Re: Submission – SSD-97528708 Mixed Use Development with Infill Affordable Housing 160 Oxford Street, Paddington

On behalf of Paddington United, I have reviewed the documentation associated with State Significant Development 97528708 (**SSD**) of 160 Oxford Street, Paddington and prepared the following commentary for your consideration. The specific documentation I have reviewed includes:

DRAWING TITLE
8.8M MRV TRUCK TURNING PATHS
Entering Shadforth Street from Liverpool Street

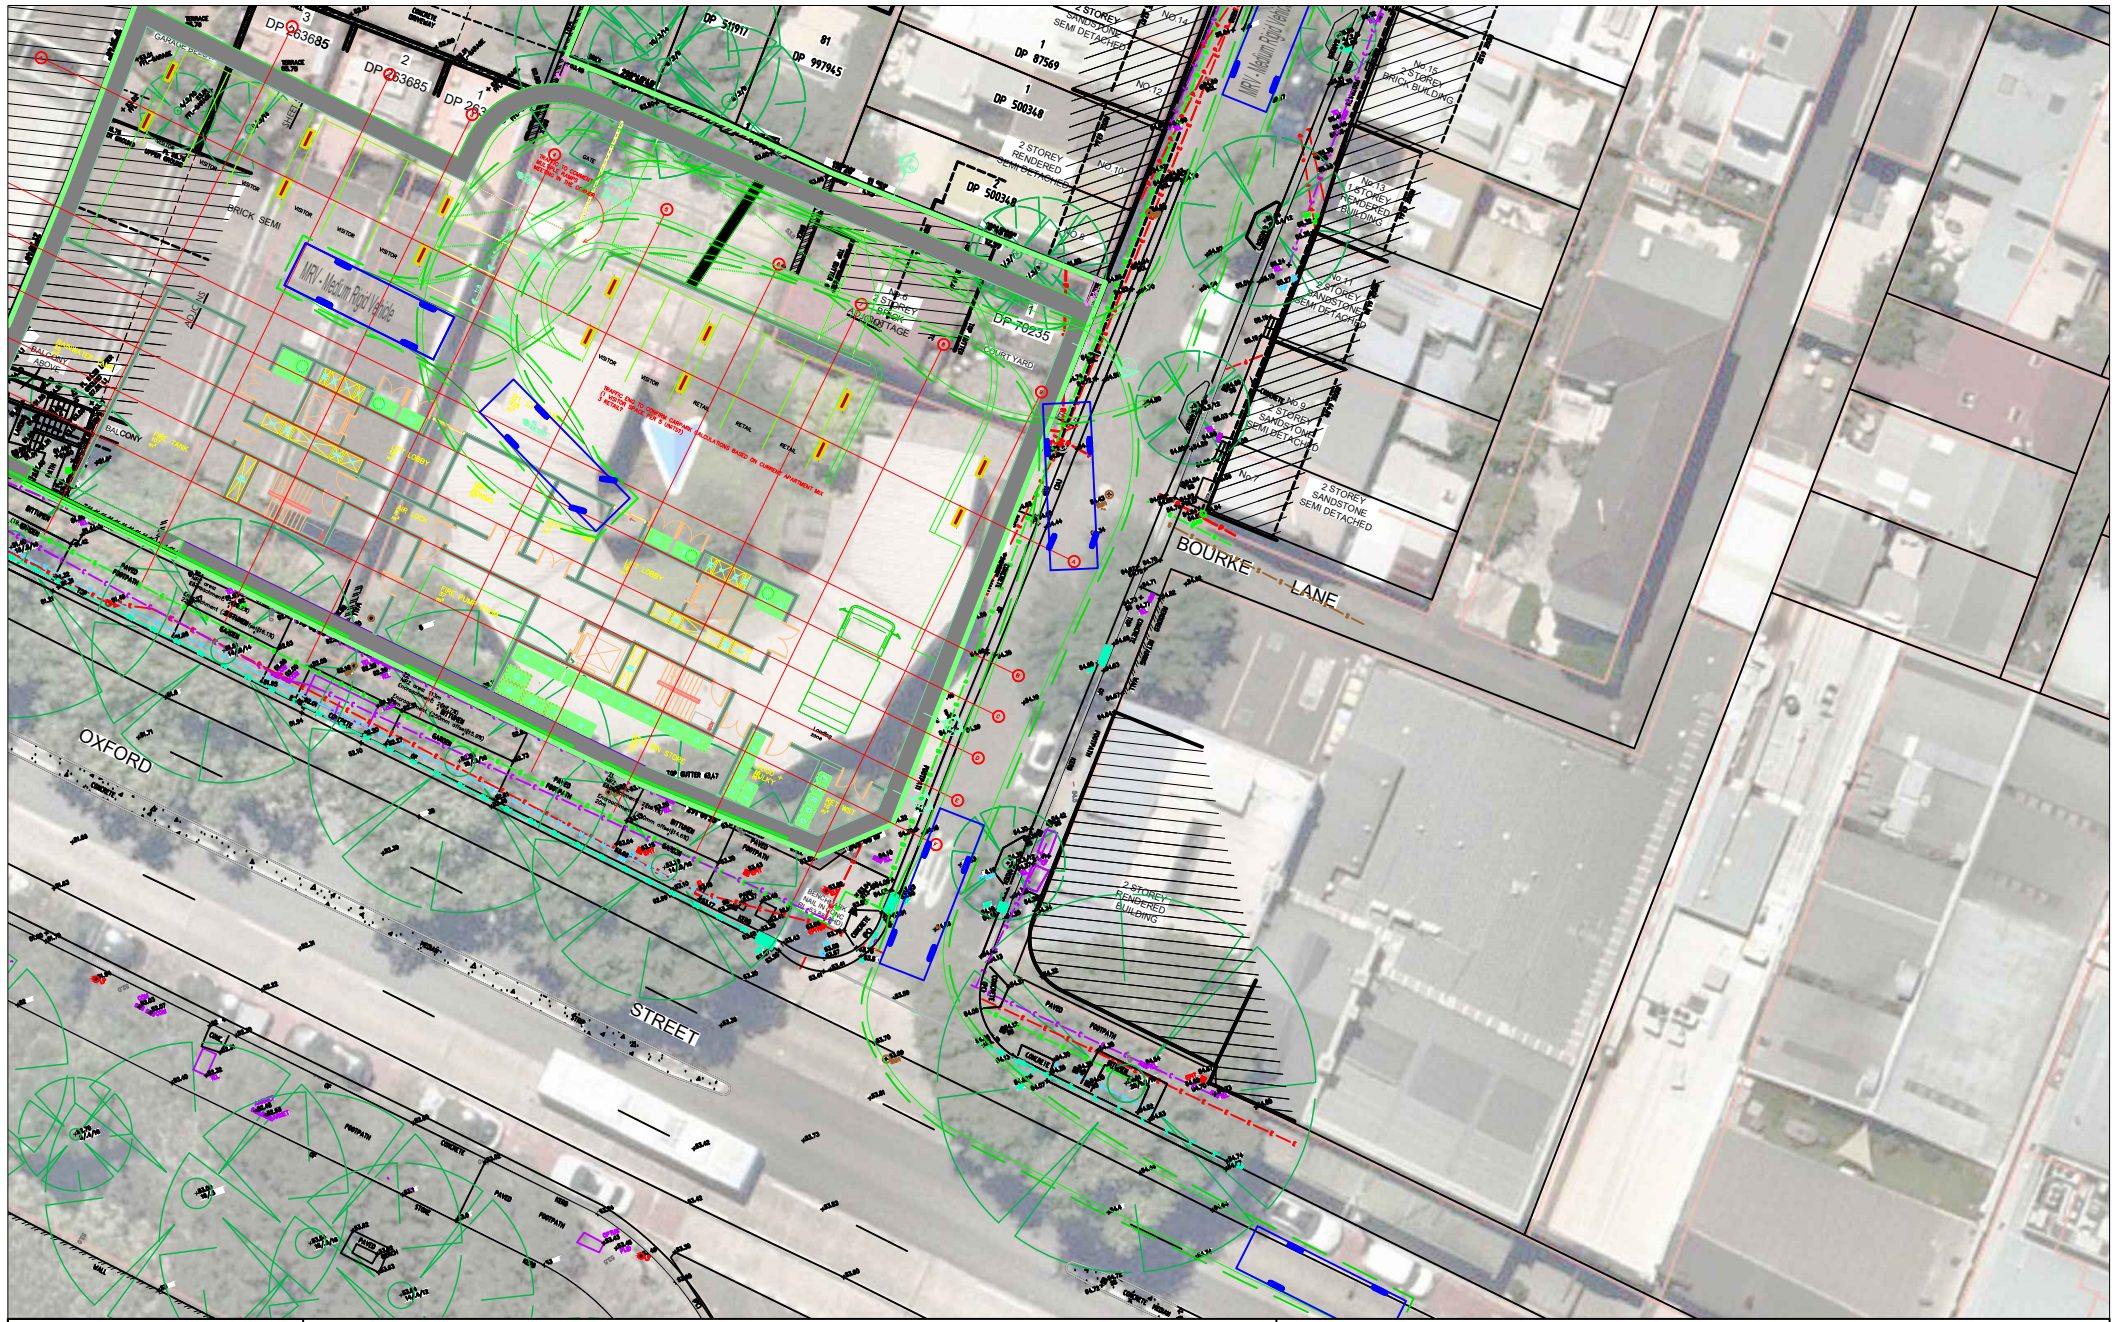
1. The CTMP proposes to use Liverpool Street and Shadforth Street for small trucks (up to 8.8m) in a southbound direction. Liverpool Street and Shadforth Street are narrow local roads with two-way flow. A high frequency of construction vehicles and trucks on these streets will result in localised congestion and potential for low-speed incidents which would not be acceptable.

TRAFFIC CONTROL PLAN No. 2
PROPOSED TRAFFIC ARRANGEMENTS DURING CONSTRUCTION & CONCRETE POURING STAGES, WHEN TRUCKS ARE LOADING & UNLOADING ALONG THE OXFORD ST KERBSIDE WORKS ZONE AREA, OUTSIDE THE BUS LANE AFTERNOON RESTRICTION TIMES
142-160 Oxford St, 13 Gipps St & 6 Shadforth St, Paddington

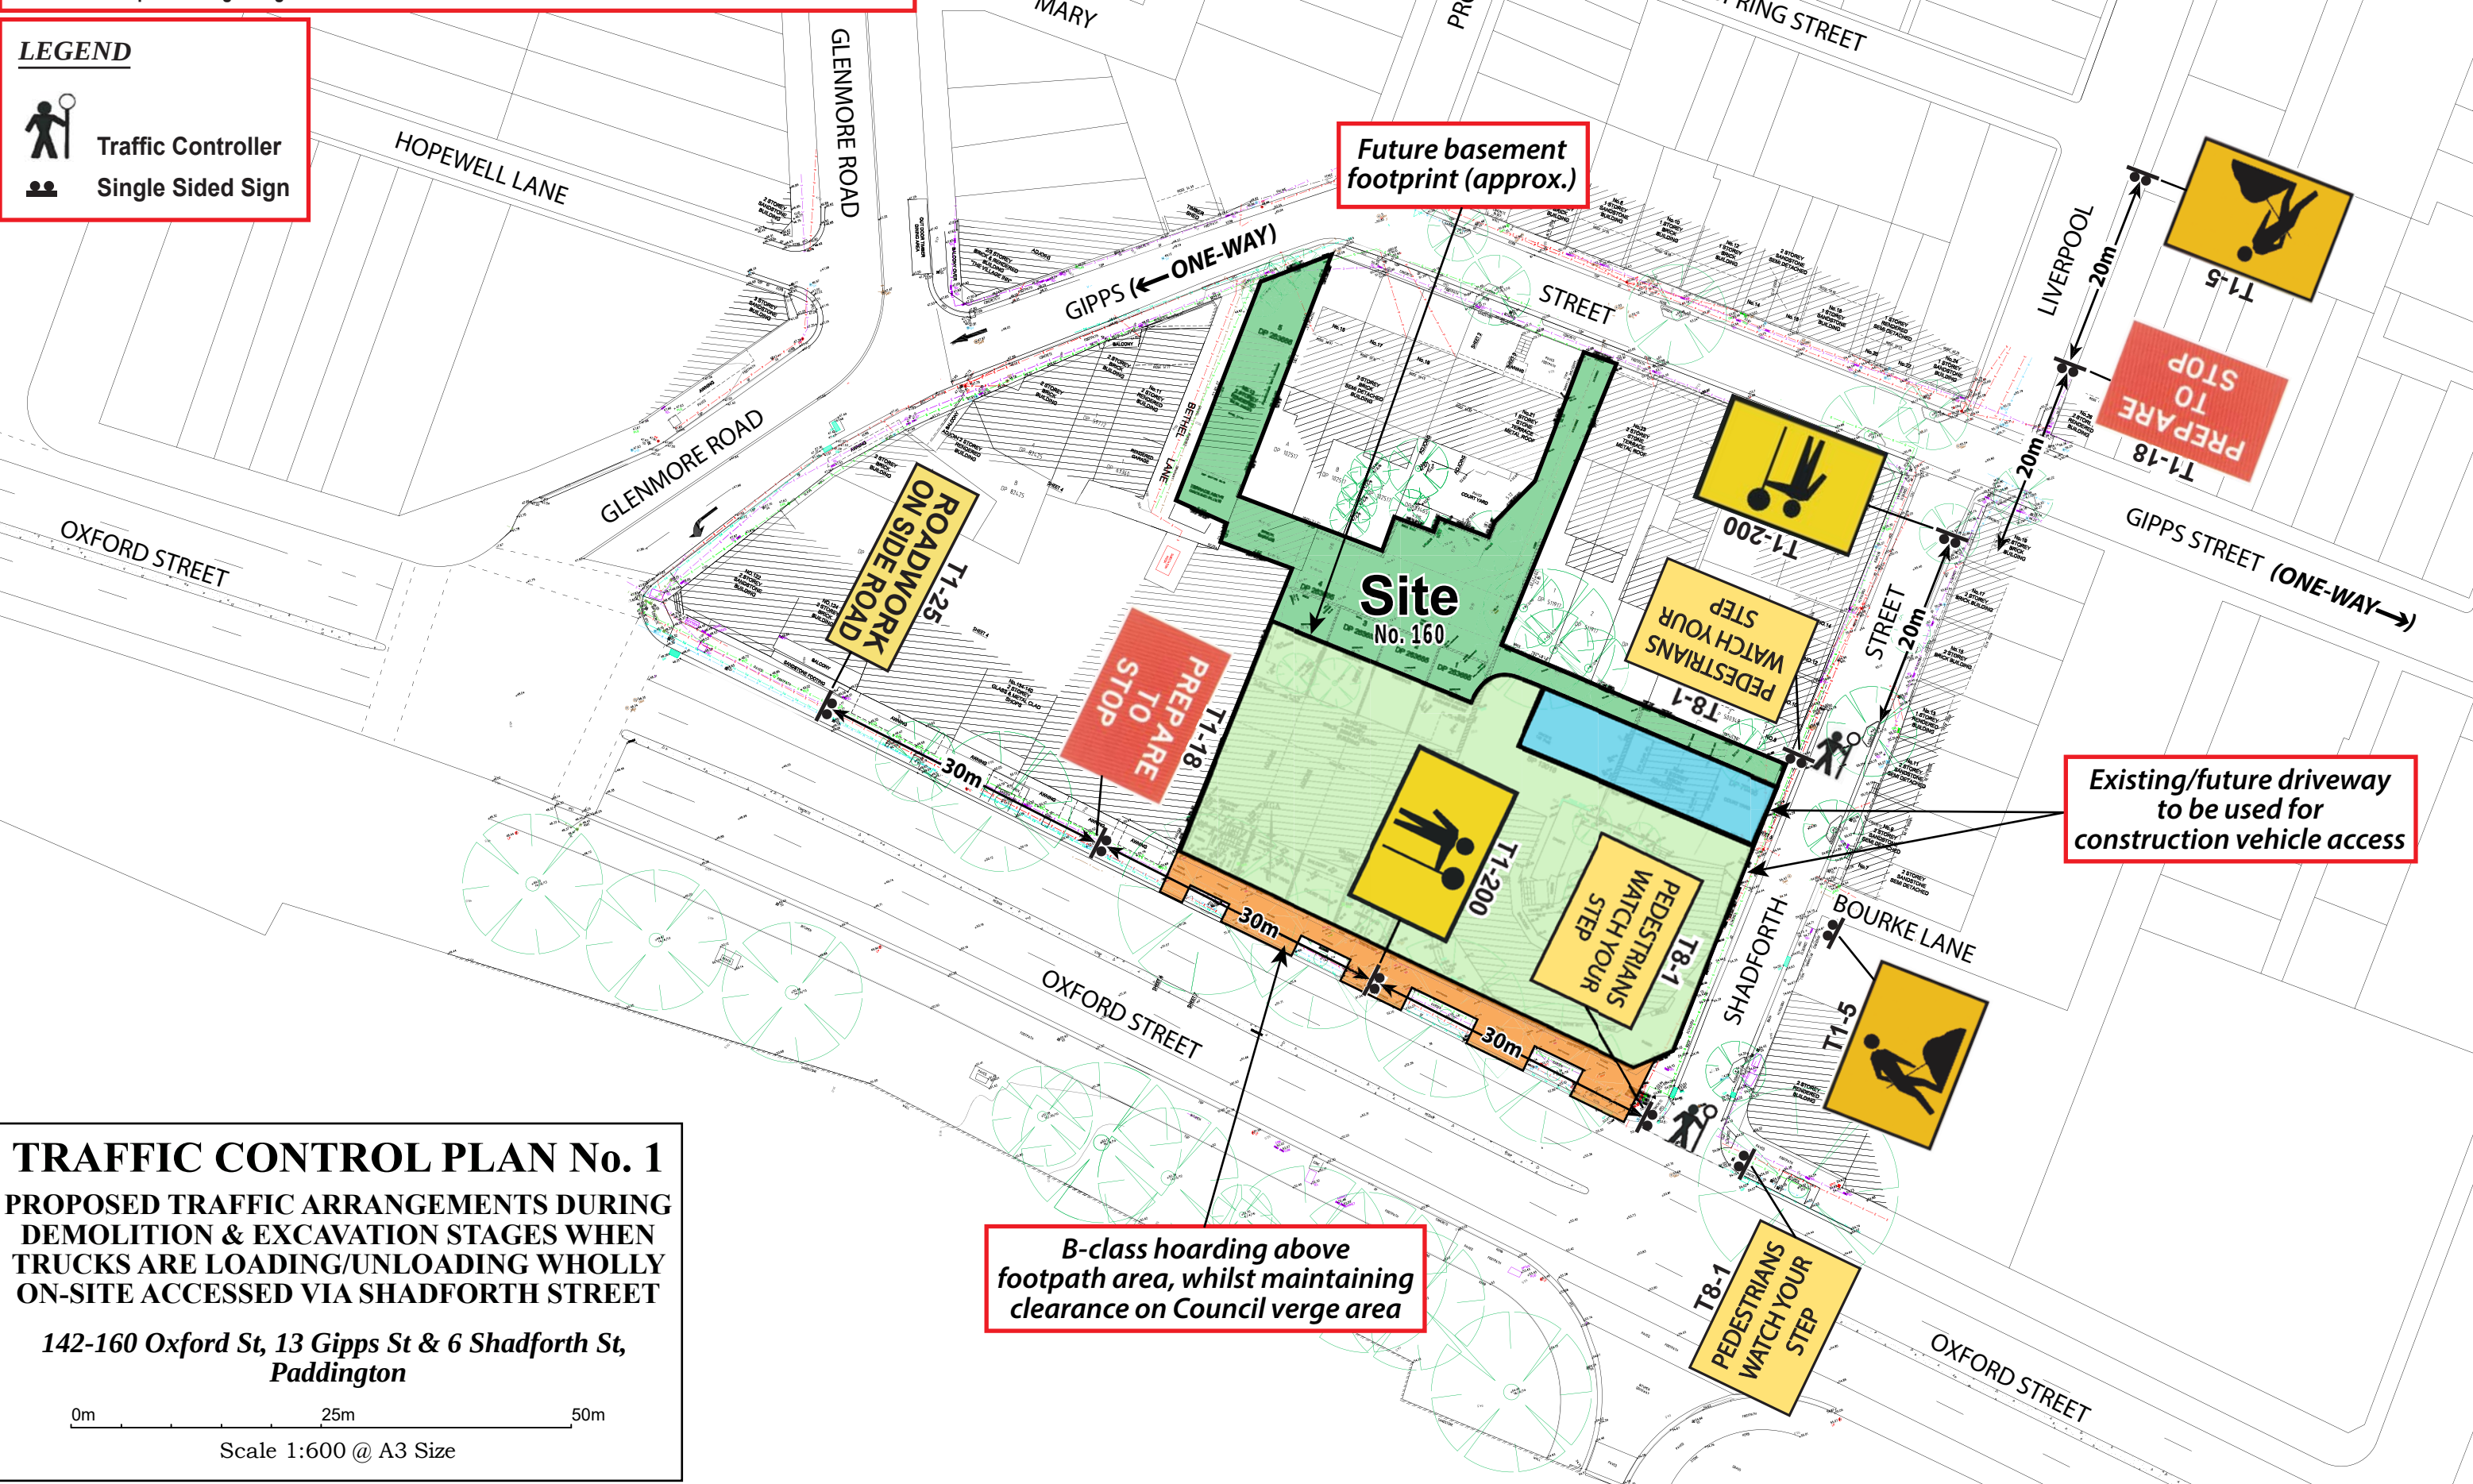
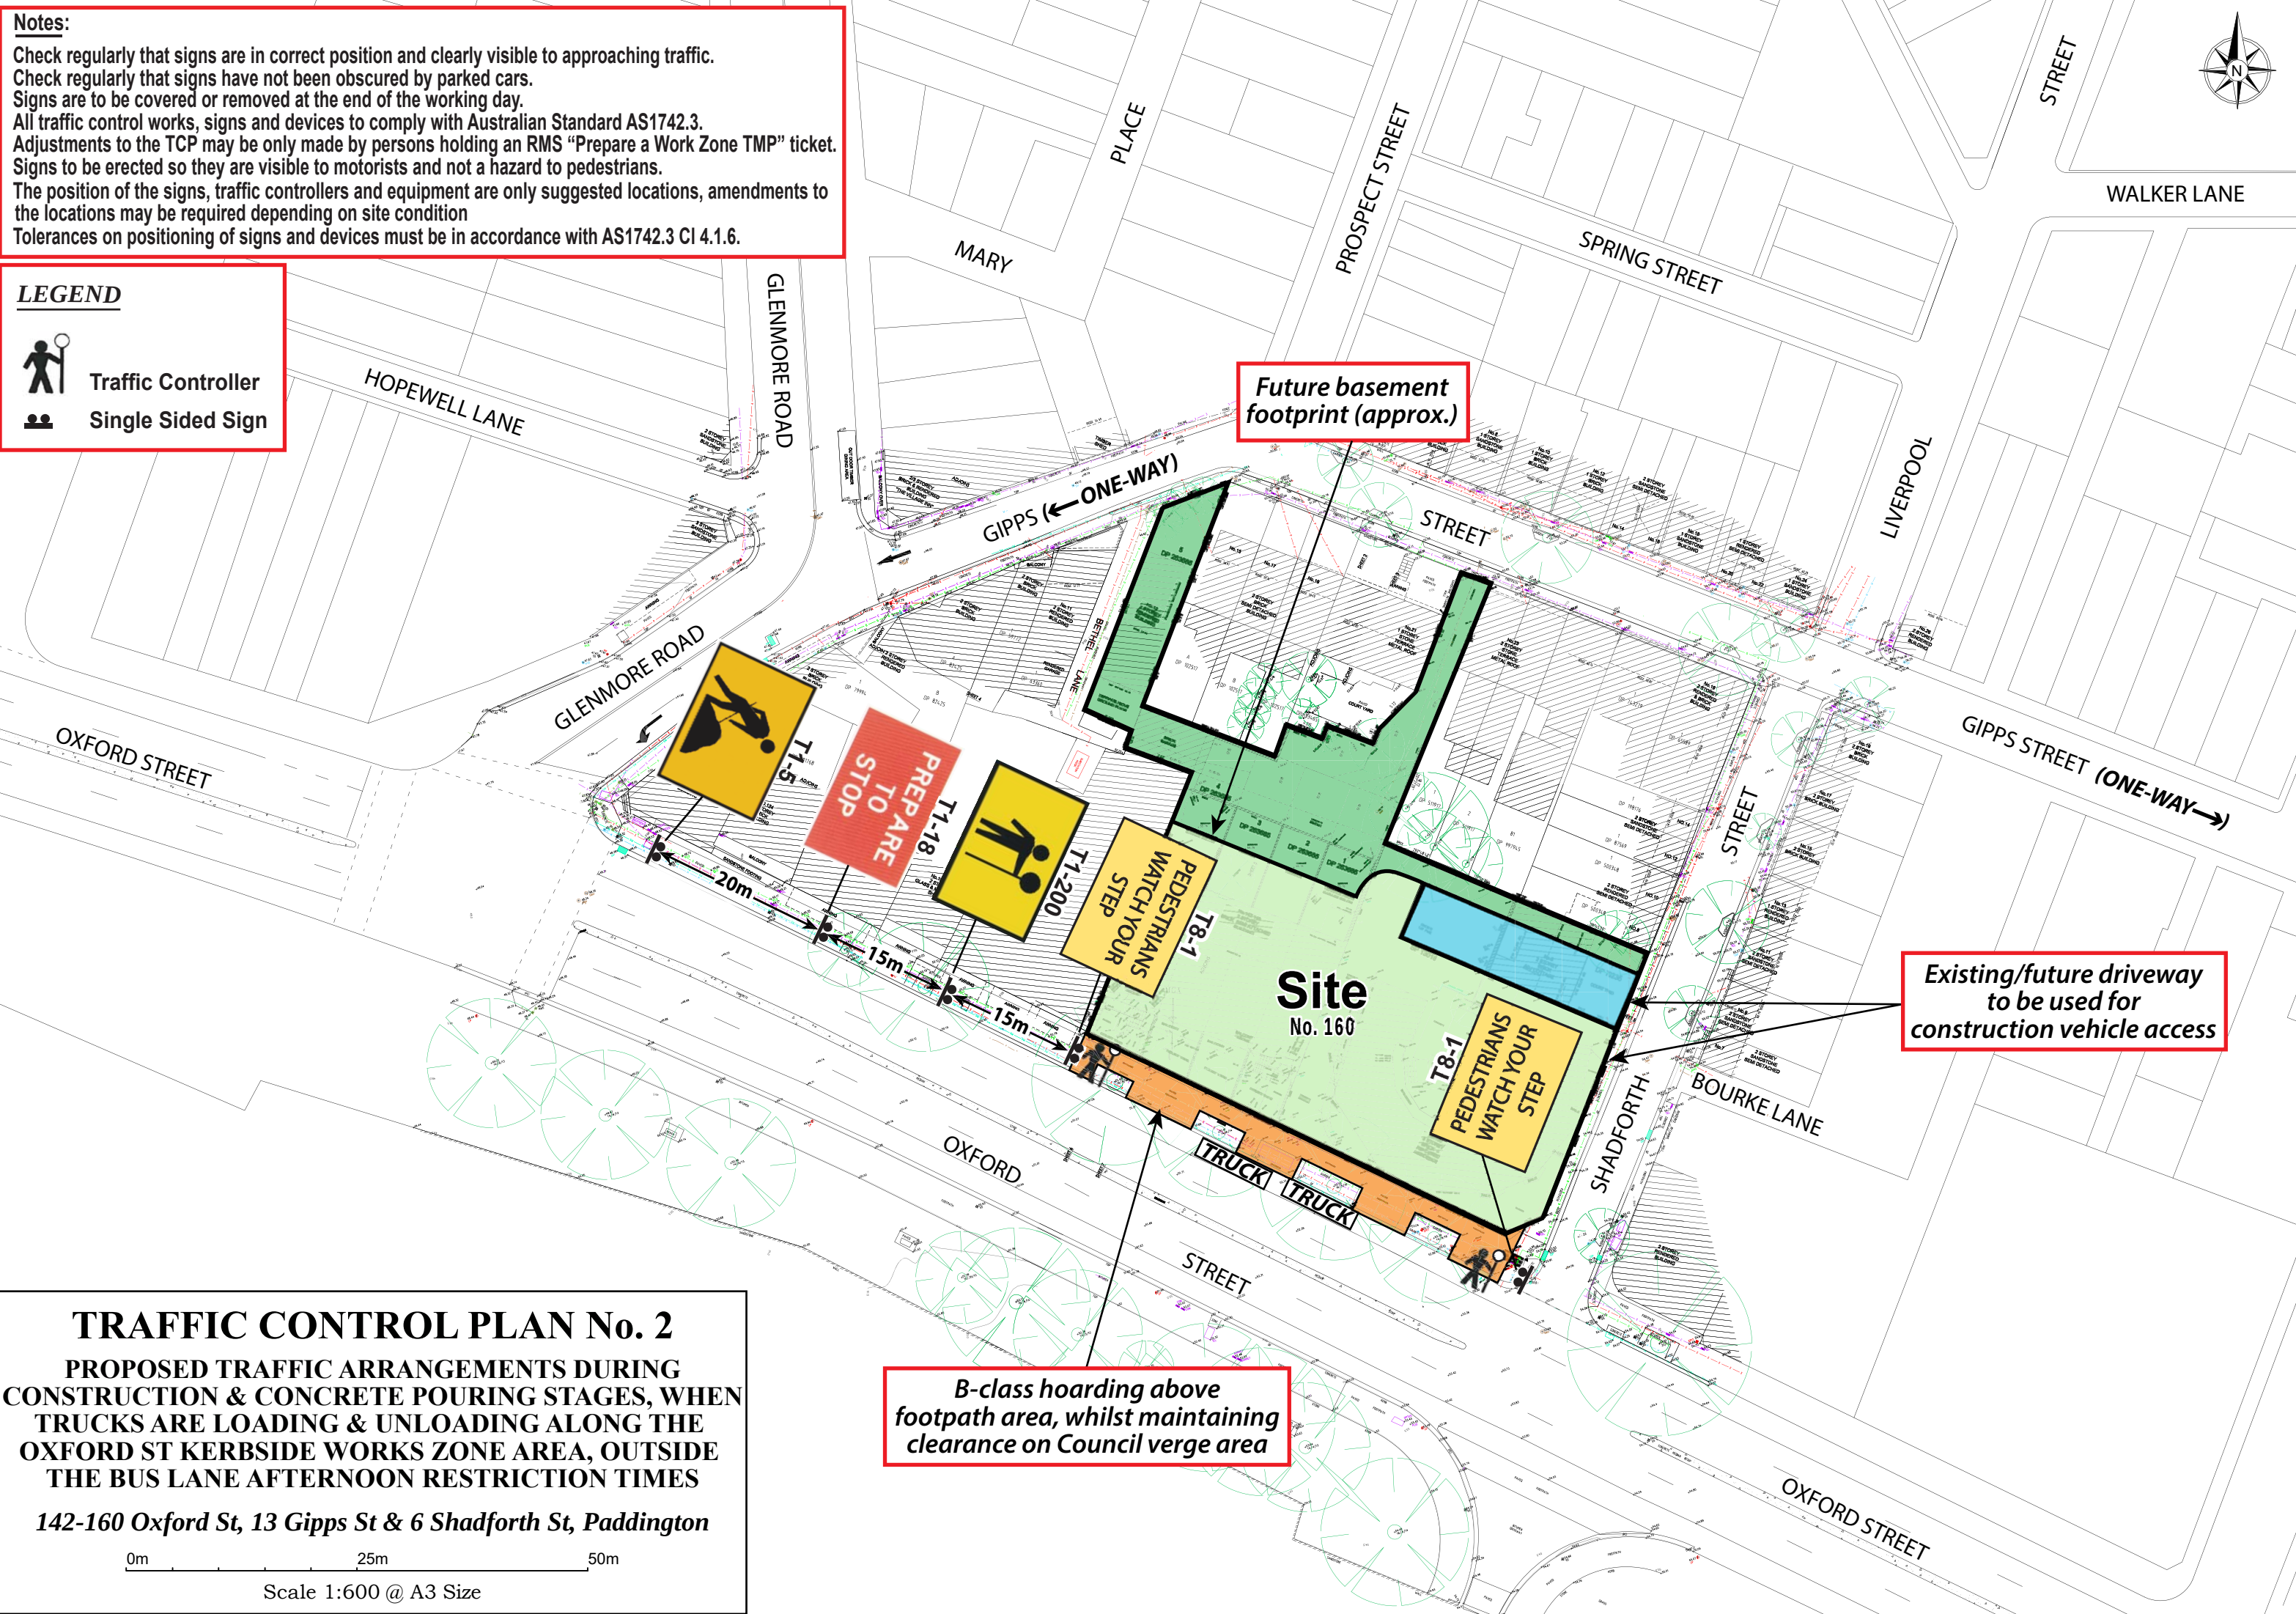
It is expected that there is a northbound travel demand on Shadforth Street for local residents to access the traffic signals at Gipps Street. An assessment of vehicle frequency and current vehicle demand within the local network has not been adequately undertaken to verify whether the impact of construction vehicles on these local streets can be justified.

The CTMP has identified that construction vehicles and trucks will be required to use local roads which have limited road width, limited passing opportunities, and limited to vehicles under 3 tonnes (Glenmore Road). An intensification of vehicle movements over a sustained period must be properly assessed to determine the suitability of the proposed construction vehicle access. The CTMP does not consider how this will impact the local road network or impact road users. No assessment, vehicle data analysis or observations are provided indicating an understanding of the impacts associated with construction of a development of this scale within a local area with severely

restricted road access. Further, it has not been demonstrated that the current CTMP appropriately mitigates against these impacts.

3. The CTMP indicates that construction vehicles will park on the local roads until a time they are able to access the basement parking. The CTMP does not consider the current limitation of on street parking or how this will impact local residents and businesses. The consideration that they will park in accordance with the signposted parking restrictions will impact parking availability in an area with high parking demand. The CTMP must provide details on how the impact of construction vehicles will be mitigated to avoid them relying on on-street parking spaces.
